Consultee Comment for planning application 22/01340/OUT

Application Number	<input type="text" value="22/01340/OUT"/>
Location	<input type="text" value="Os Parcel 6124 East Of Baynards Green Farm Street To Horwell Farm Baynards Green"/>
Proposal	<input type="text" value="Application for outline planning permission (all matters reserved except means of access (not internal roads) from B4100) for the erection of buildings comprising logistics (use class B8) and ancillary offices (use class e(g)(i)) floorspace; energy centre, hgv parking, construction of new site access from the B4100; creation of internal roads and access routes; hard and soft landscaping; the construction of parking and servicing areas; substations and other associated infrastructure."/>
Case Officer	<input type="text" value="Tom Webster"/>
Organisation	<input type="text" value="Drainage (CDC)"/>
Name	<input type="text" value="Tony Brummell"/>
Address	<input type="text" value="Cherwell District Council Bodicote House White Post Road Bodicote Banbury OX15 4AA"/>

Project Title: **SURFACE WATER DRAINAGE STRATEGY**
PLANNING

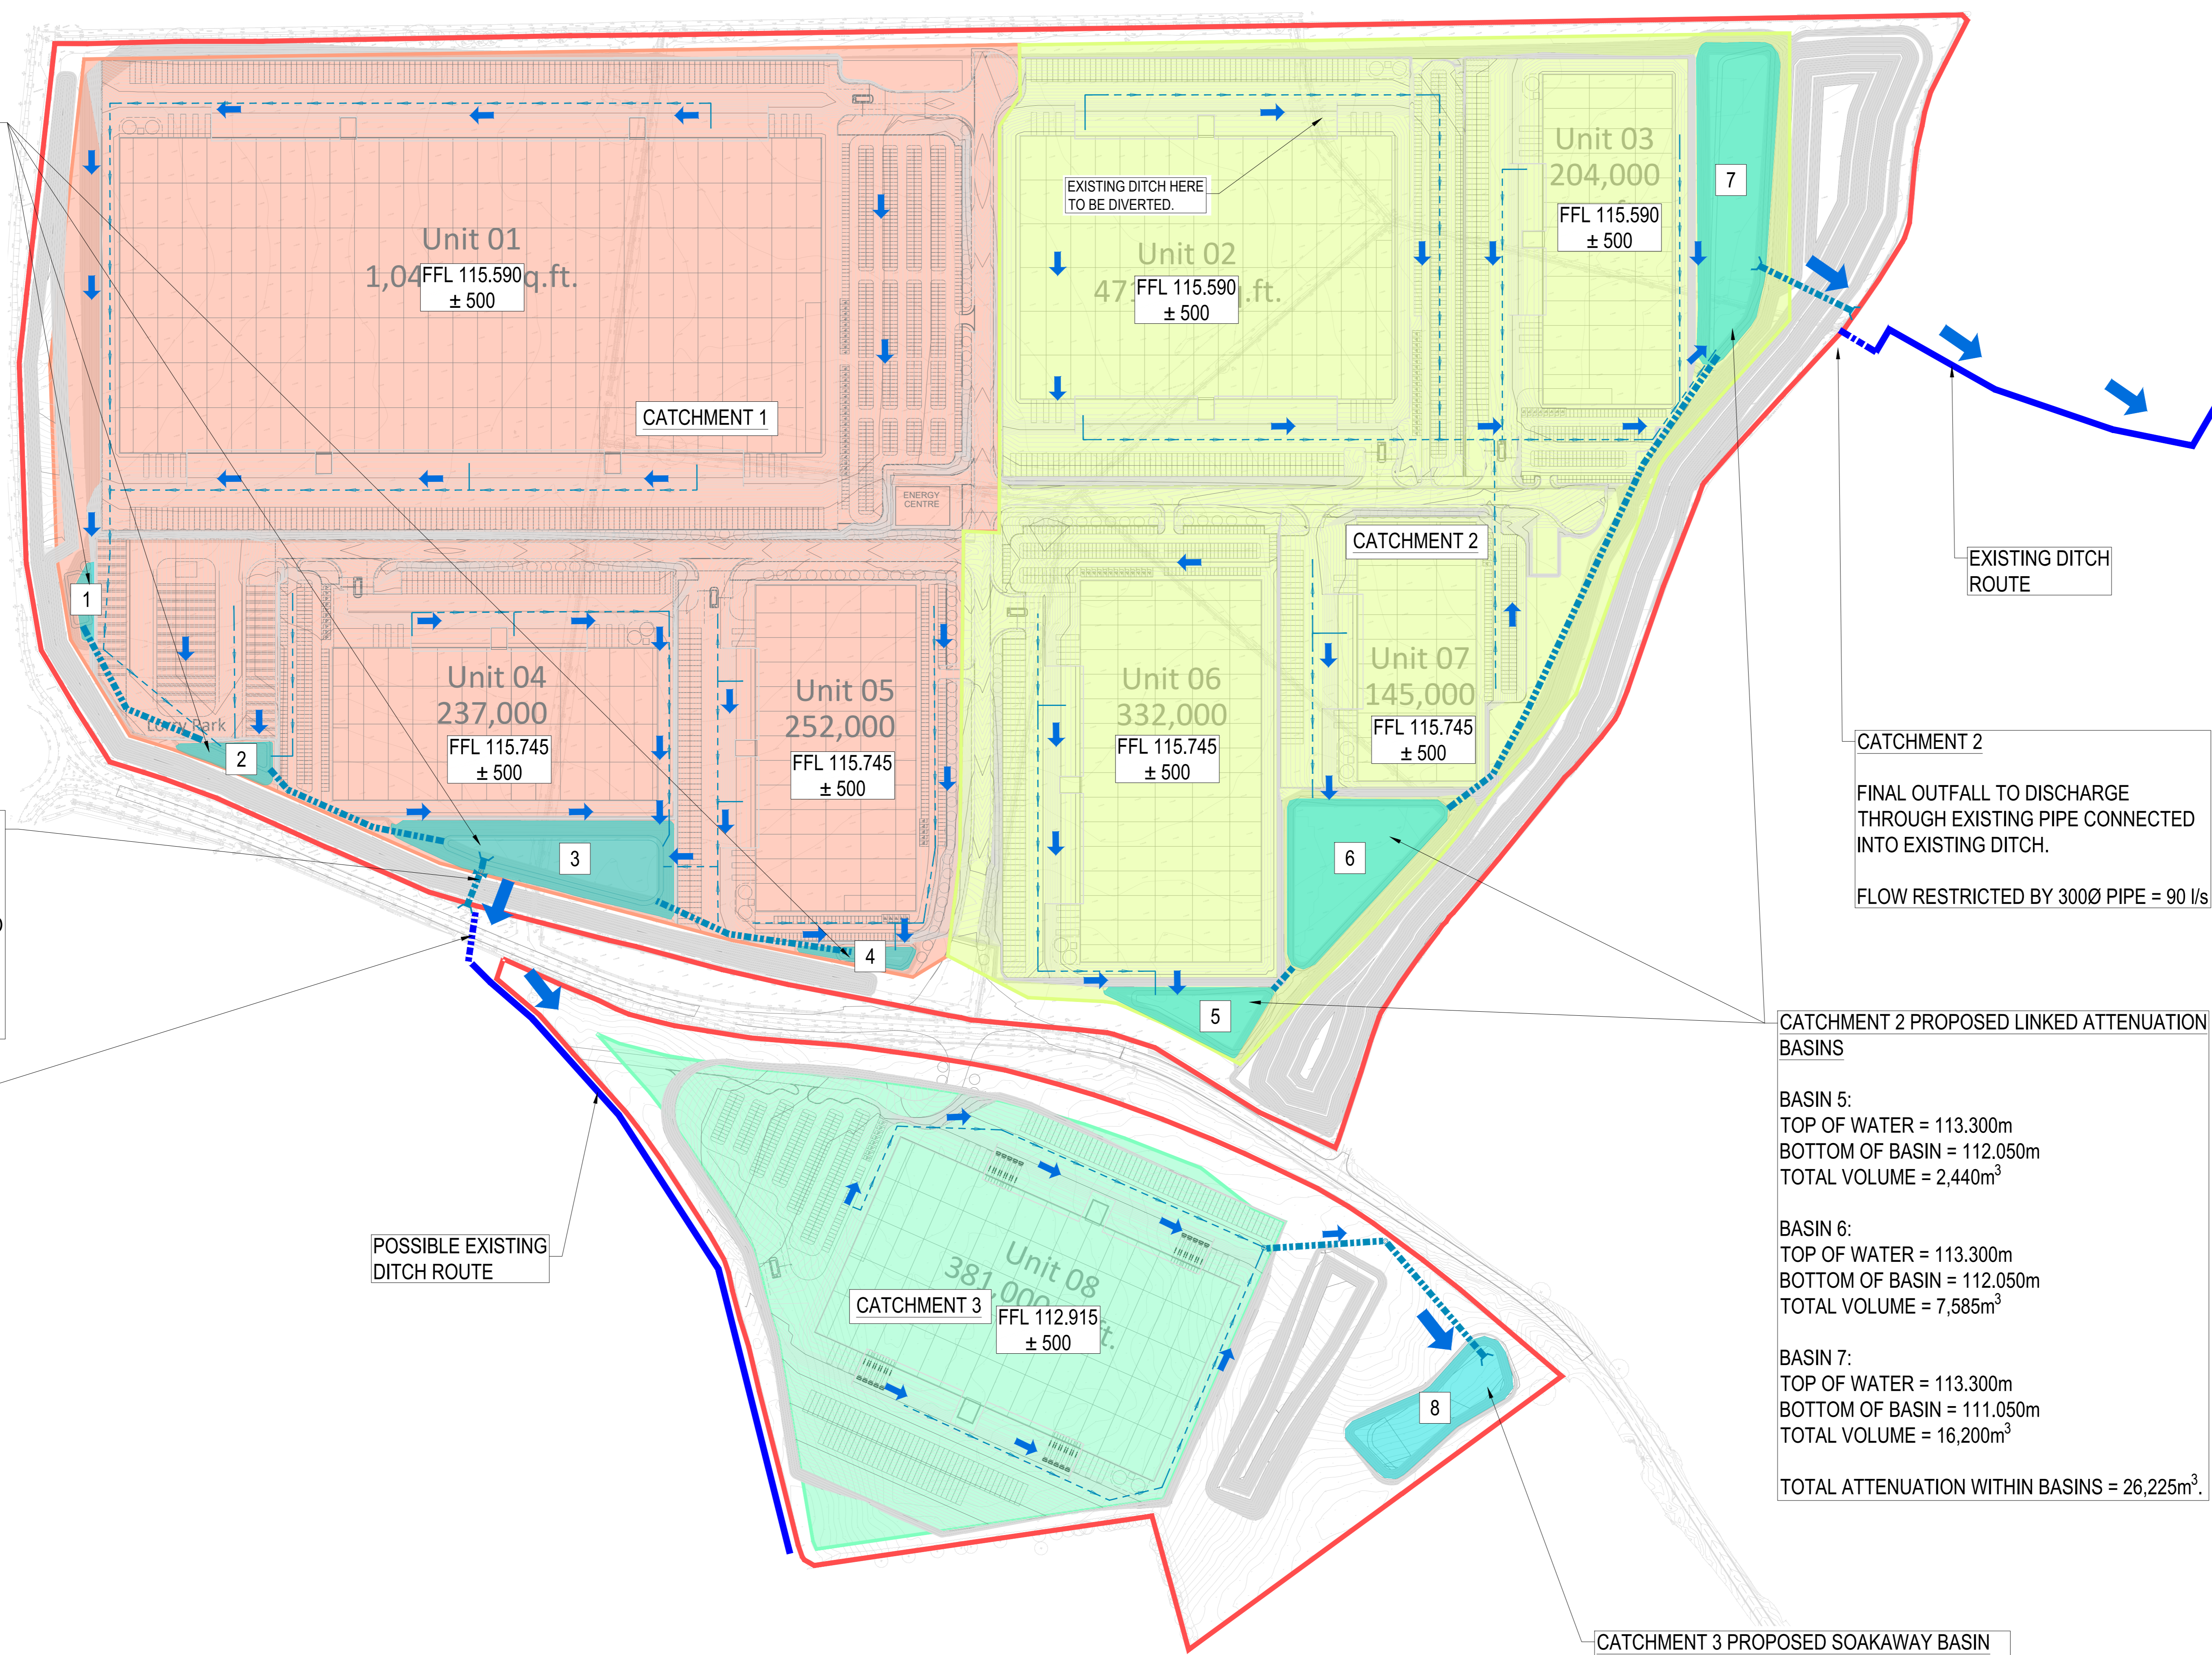
Type of Comment	<input type="text" value="Comment"/>
Type	<input type="text"/>
Comments	<input type="text" value="Surface water Drainage: - A hybrid solution is proposed whereby as much infiltration as is feasible will be used supplemented by controlled discharges to a watercourse/ditch system from three sub-catchments. This is supported in principle as it follows the recommended SuDs hierarchy. A detailed multi-location ground investigation survey will be required to inform the final detailed design.

Foul Drainage: - A pumped solution to Stoke Lyne STW, which is operated by Anglian Water, is proposed. It is clear from the estimated foul flows generated on the site that the sewage treatment facility will require substantial advance upgrading."/>
Received Date	<input type="text" value="22/06/2024 17:30:53"/>
Attachments
